Angus Place Coal Project (06 0021 Modification 1)

I refer to your letter received 29 November 2010 inviting comments, including any recommended conditions of approval, from Industry and Investment NSW (I&I NSW) on the Environmental Assessment (EA) for the proposed modification to the Angus Place Colliery project approval.

DRG. No. FIGURE 3

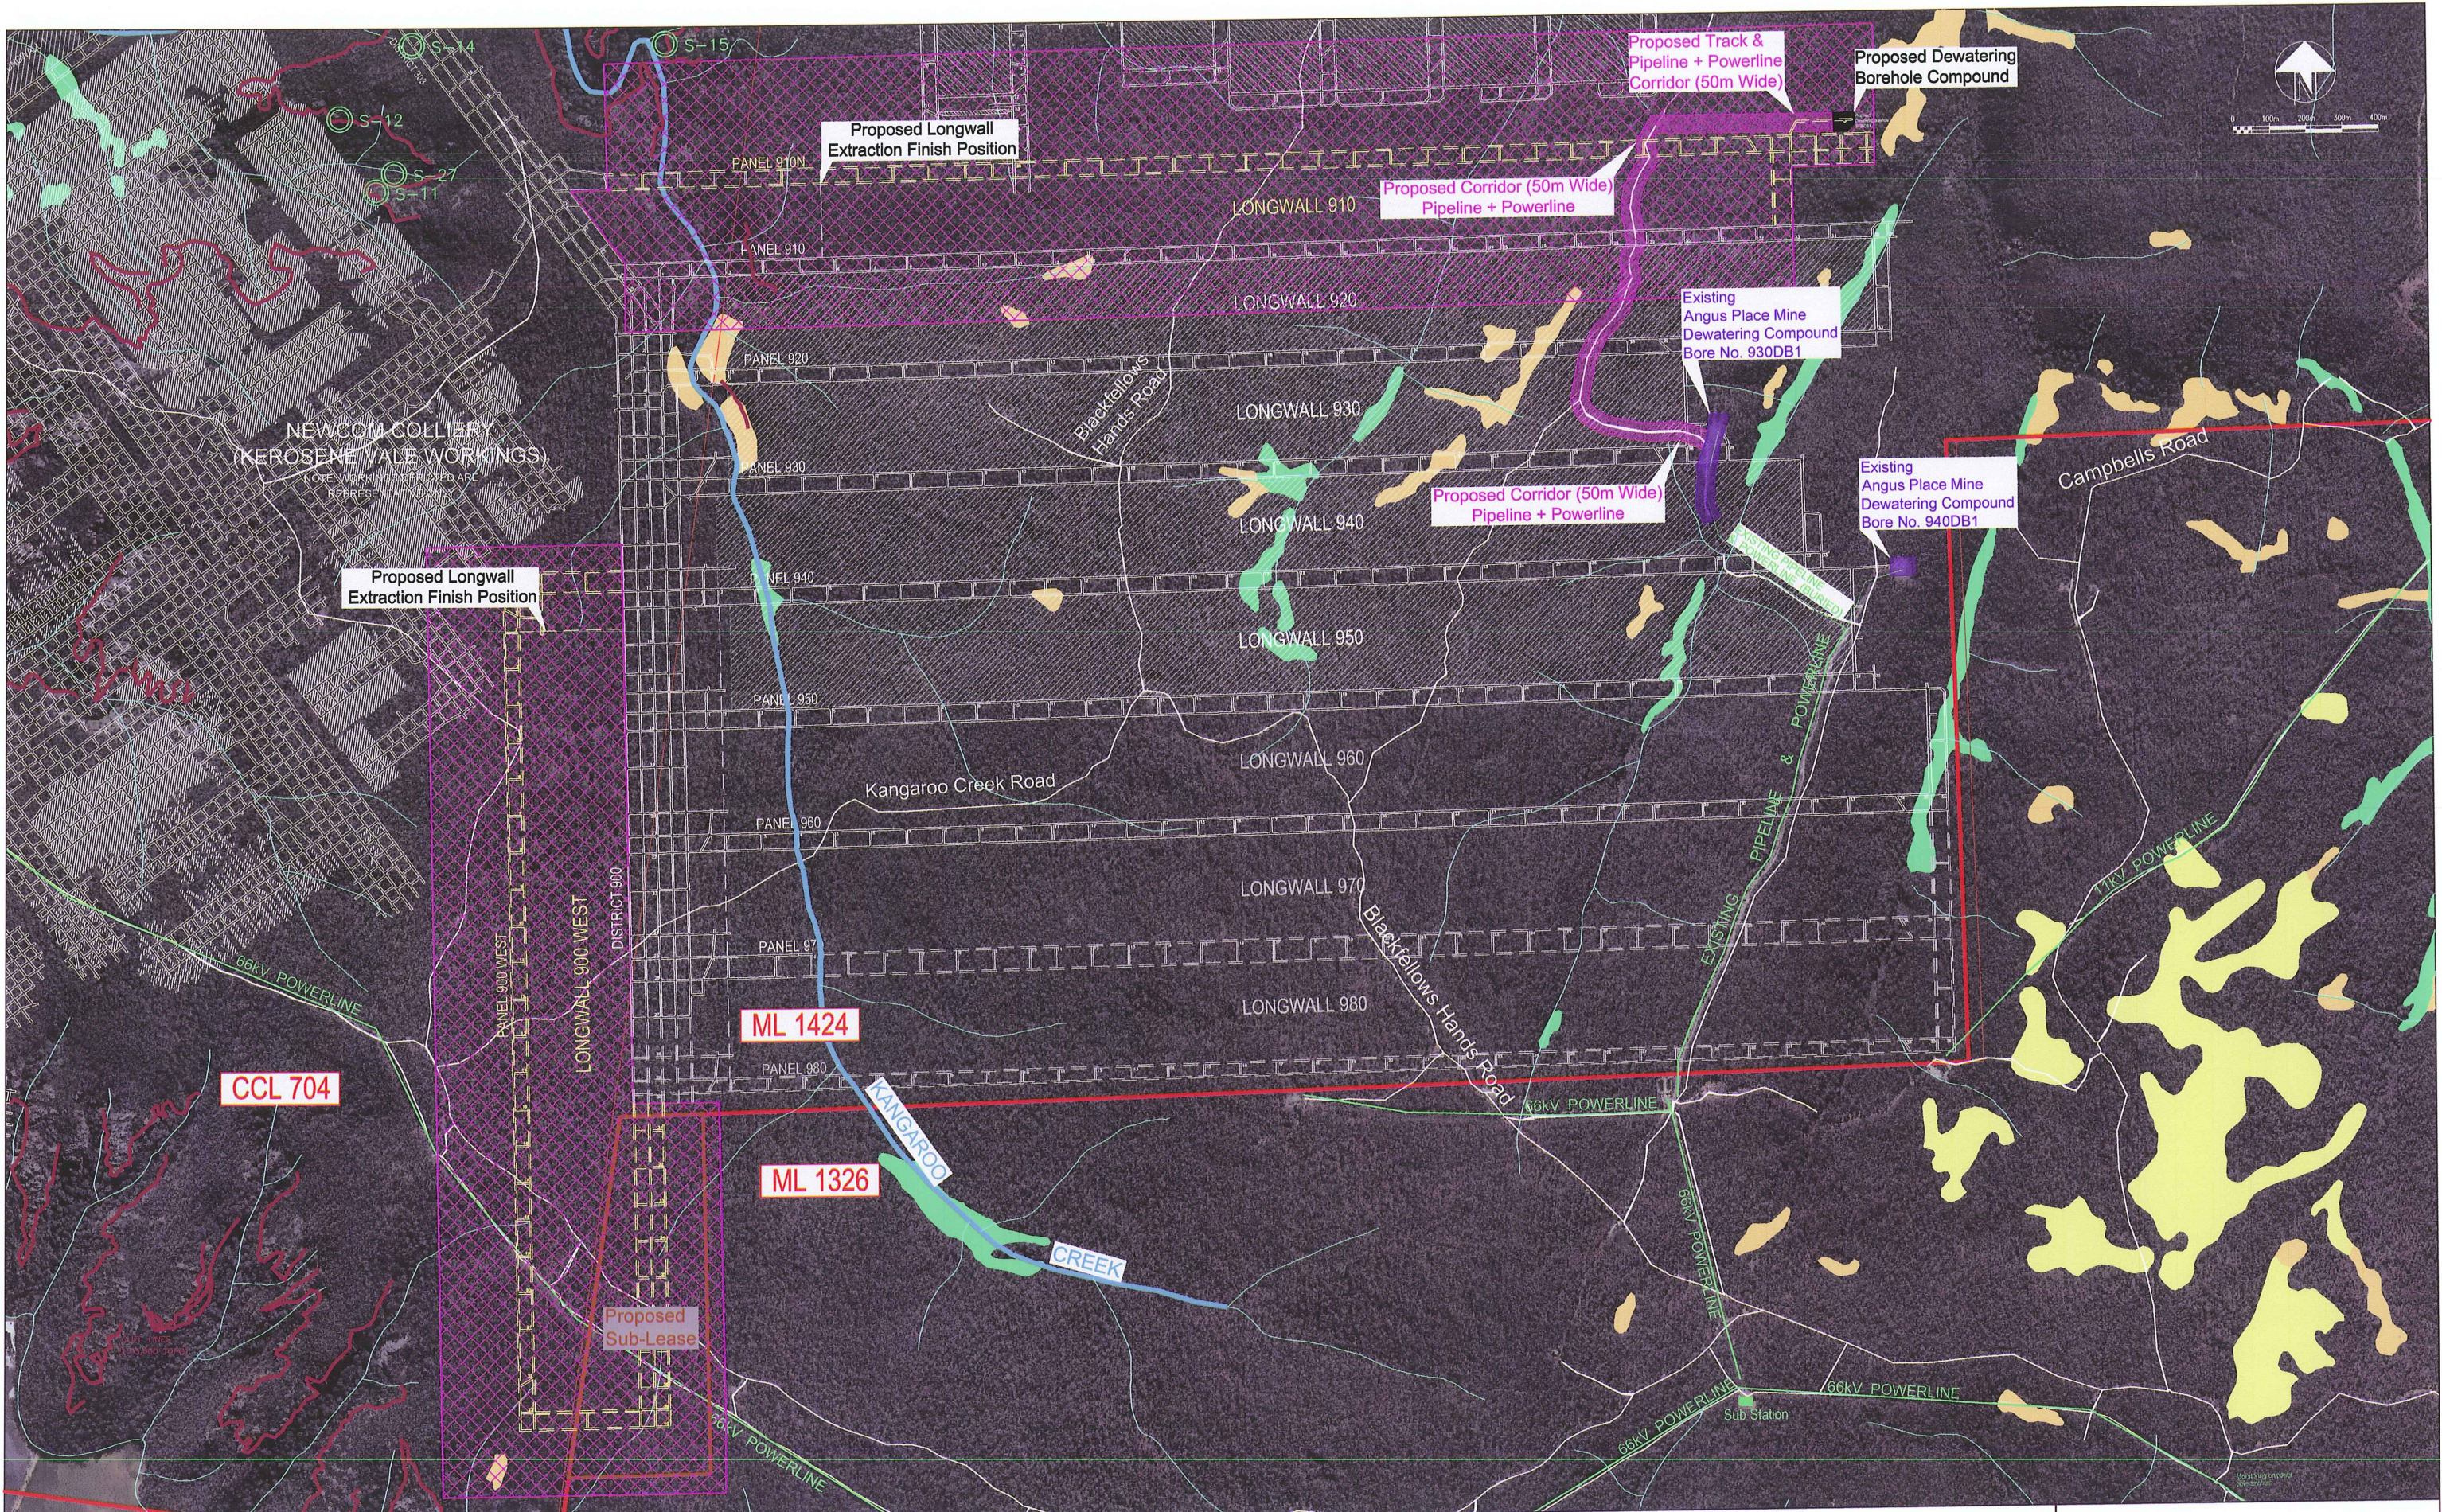
- Installation of the new dewatering bore is noted as requiring approx 0.28 ha of clearing. While this may reflect the final compound size, through previous experience with construction of Centennial Coal (Springvale Colliery) adjacent "Bore 6", Forests NSW estimates that disturbance from truck movements, storage of supplies, parking, and water management is likely to well exceed this area. In addition there may be a requirement to further clear an "Asset Protection Zone" around this infrastructure, upon consultation with the NSW Rural Fire Service. It is important that the approval reflects the likelihood of an area greater than 0.28ha being disturbed by this installation.

- Overhead powerlines are regular sources of bushfires. To protect the forest from fire Forests NSW requests that **all new powerline installations be underground**. Any above ground transformers should be located within existing/new compounds where possible.

- Justification for widening of existing road alignments to 25 metres for the Dewatering Bore Access Tracks is not provided within the EA. Forests NSW considers that the width of clearing should be that required for a suitable access track and associated trenching, which may in fact be contained within the width of the existing track.
